Re: Portland Retirement Residence

These are responses to your email comments/redlines dated March 23, 2016.

SHEET A0.1

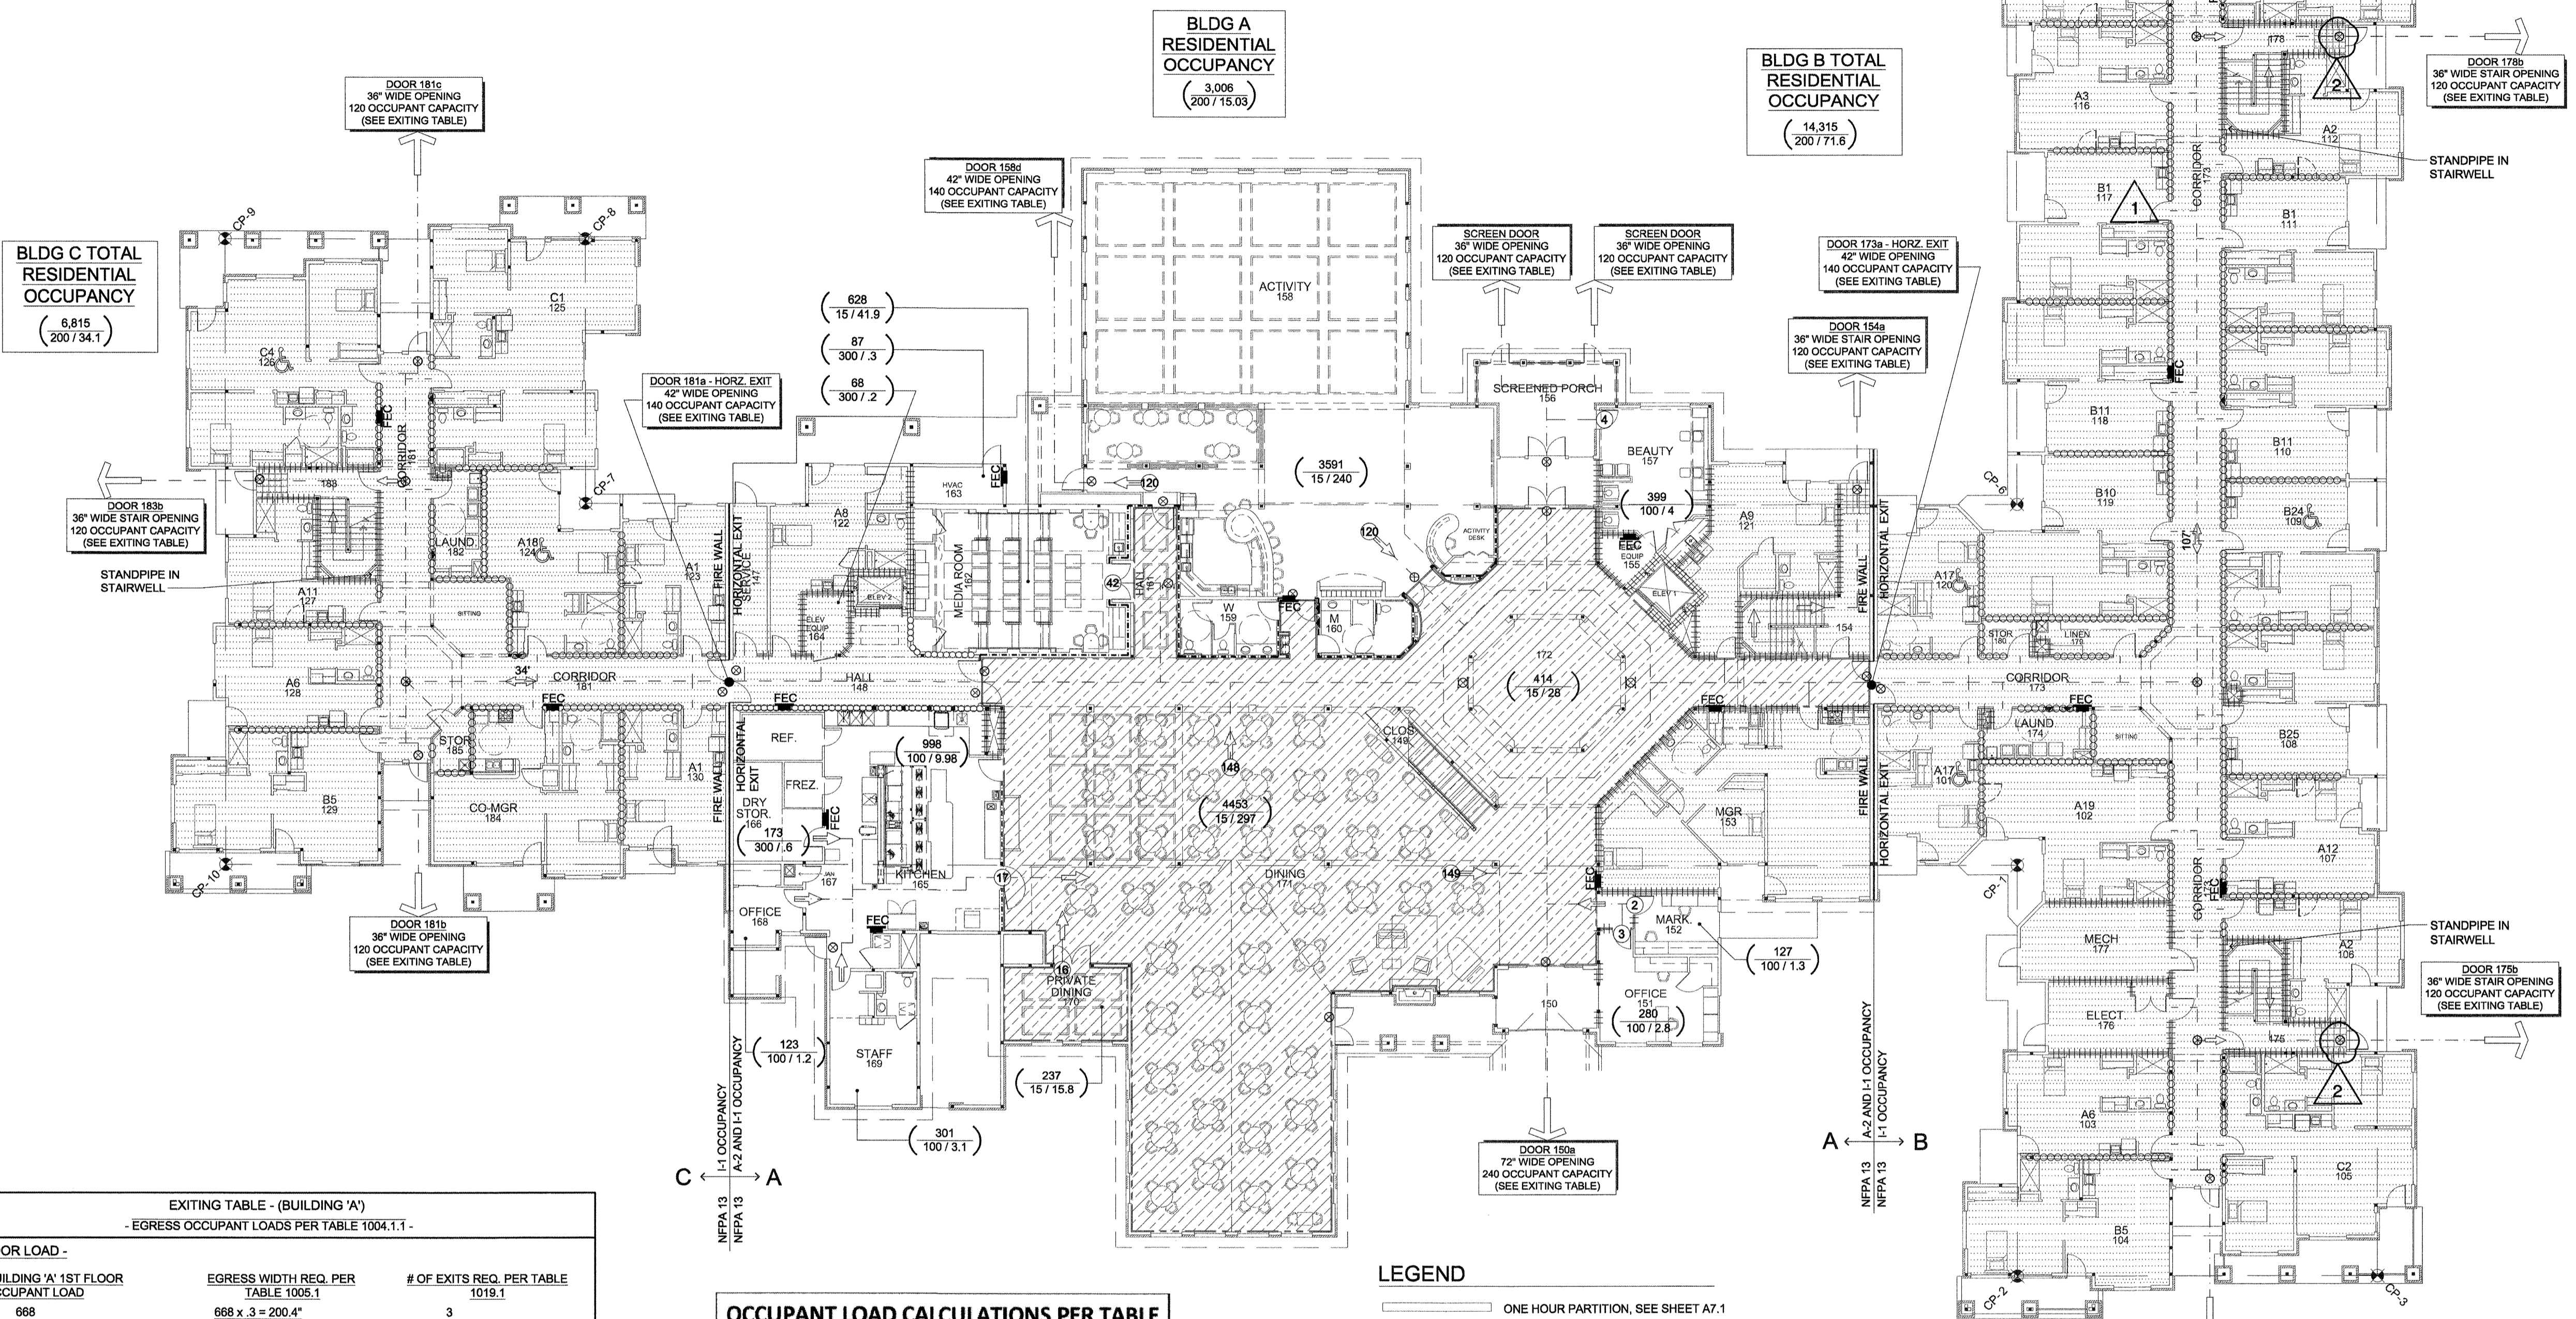
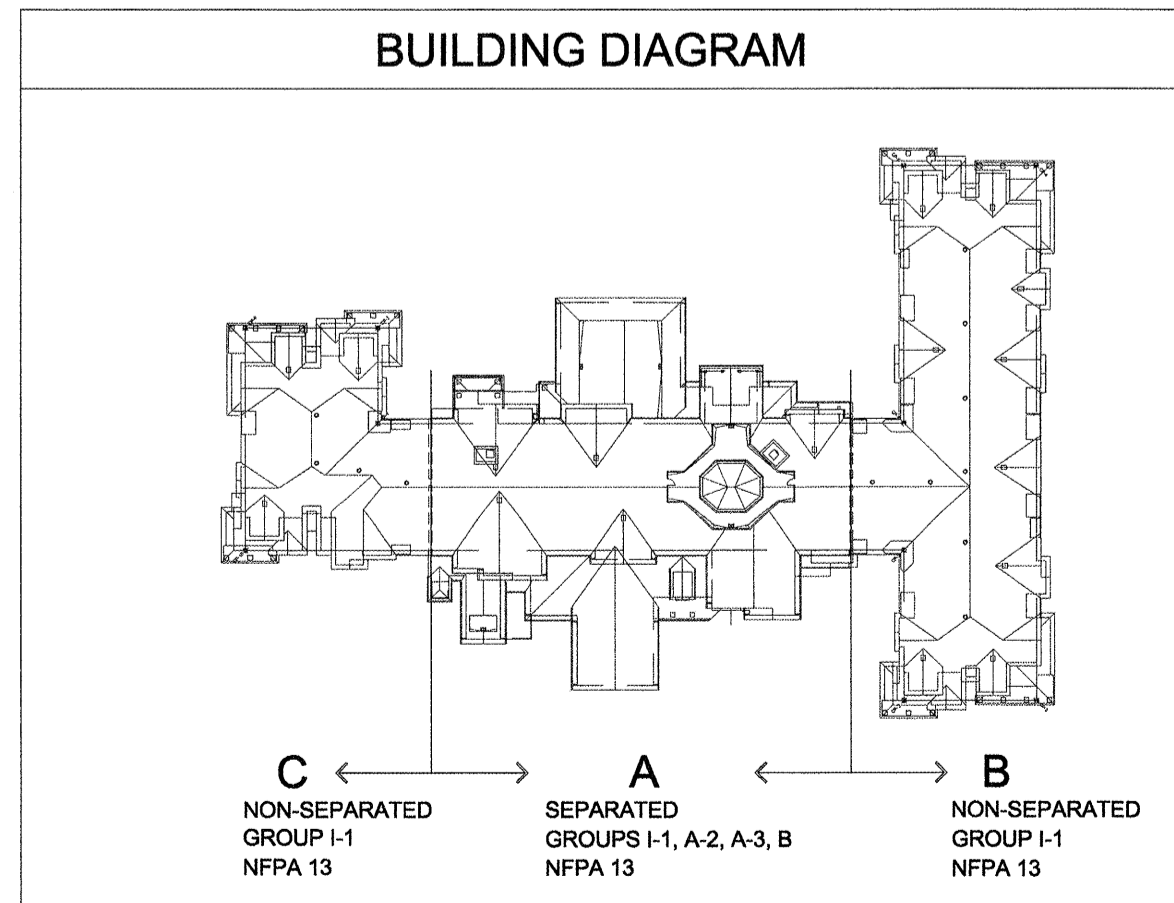
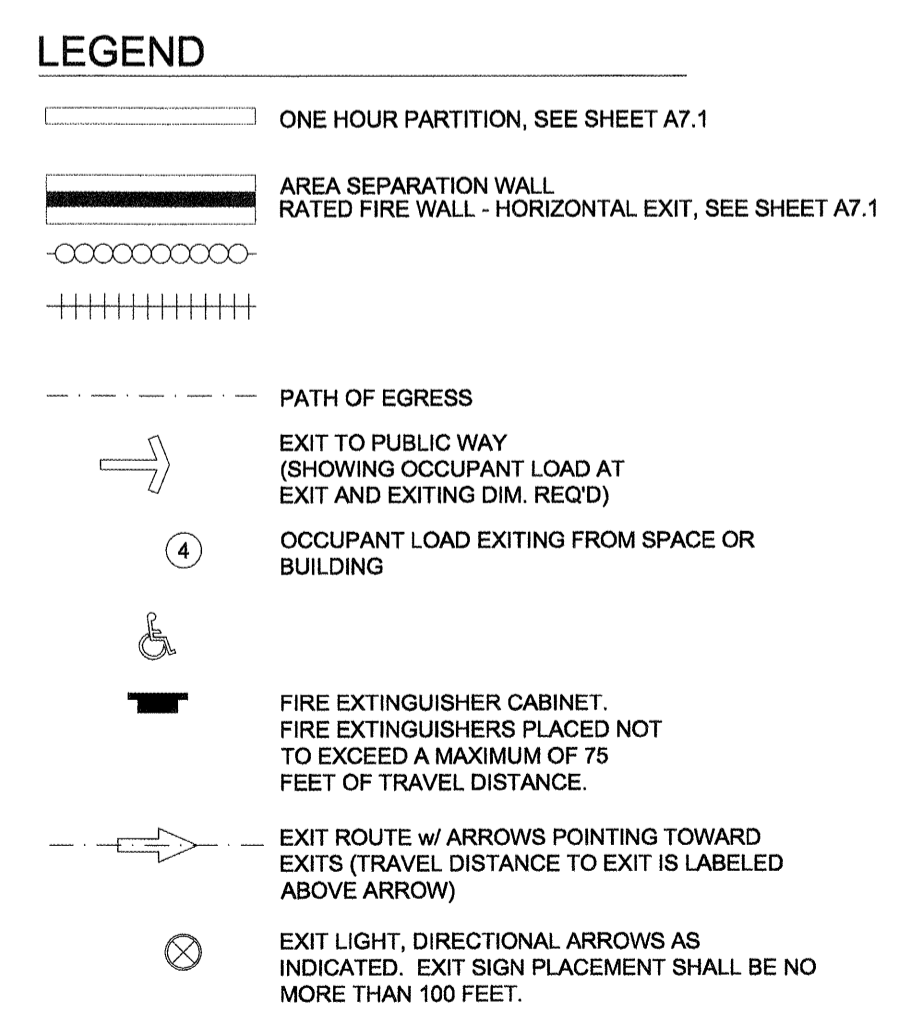
1. Clarify why one of the two fire walls shows an extension beyond the exterior wall and the other does not? Provide continuity on all plan sheets. Reference the code section this is associated with in the code analysis.

2. The legend looks to be incomplete and missing some wall components. Please revise legend to include all wall types with definitions.

Please note that we have revised the firewalls extensions on A0.1 to be consistent to 706.5.2

Please note that we have included the missing information on the wall legend. Note this has been revised on sheets A0.1 – A0.5.

SHEET A0.3

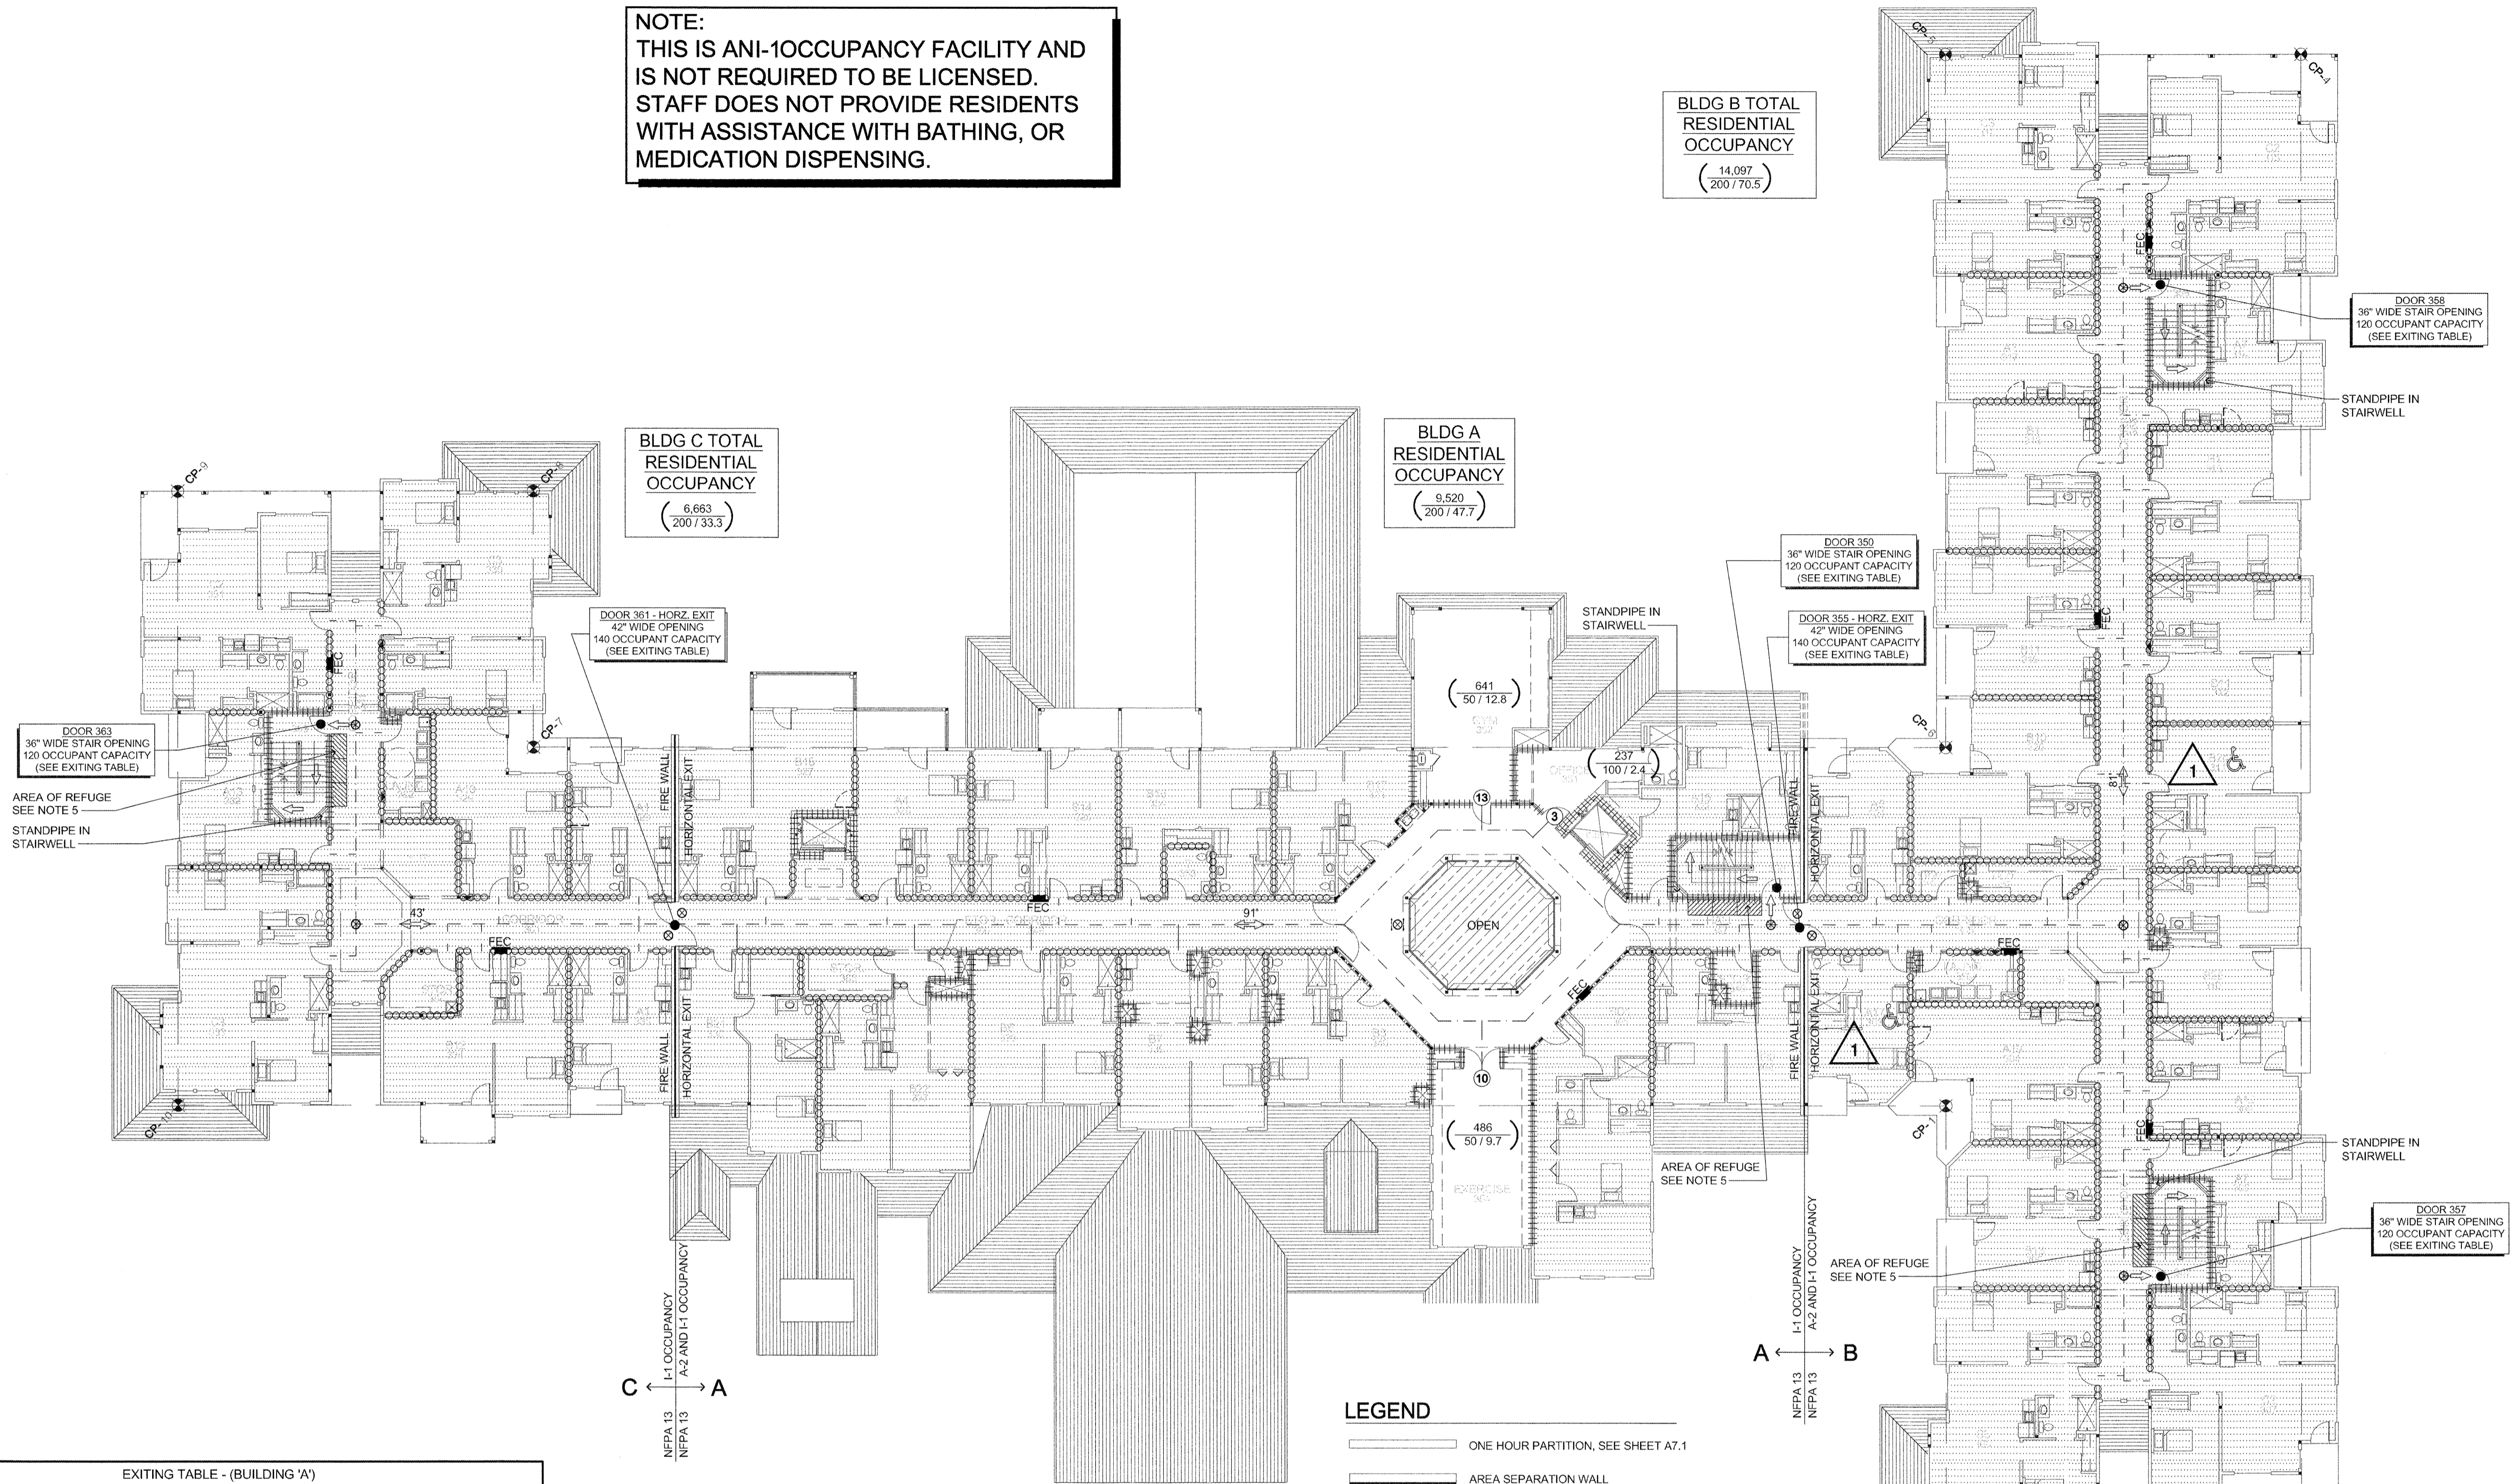
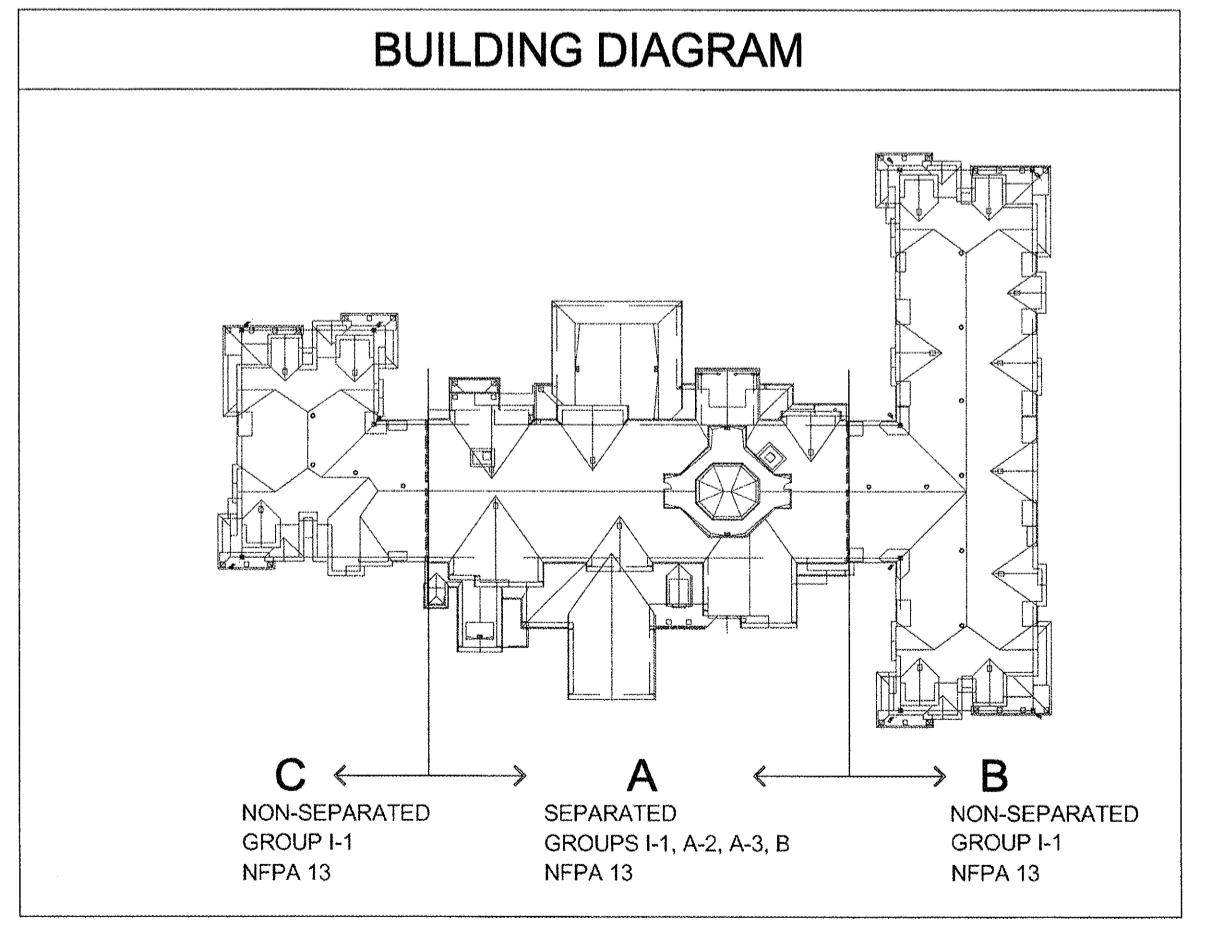
5. This exiting table is referencing the incorrect floor level. Please revise.

Please see revised exiting table on sheet A0.3.
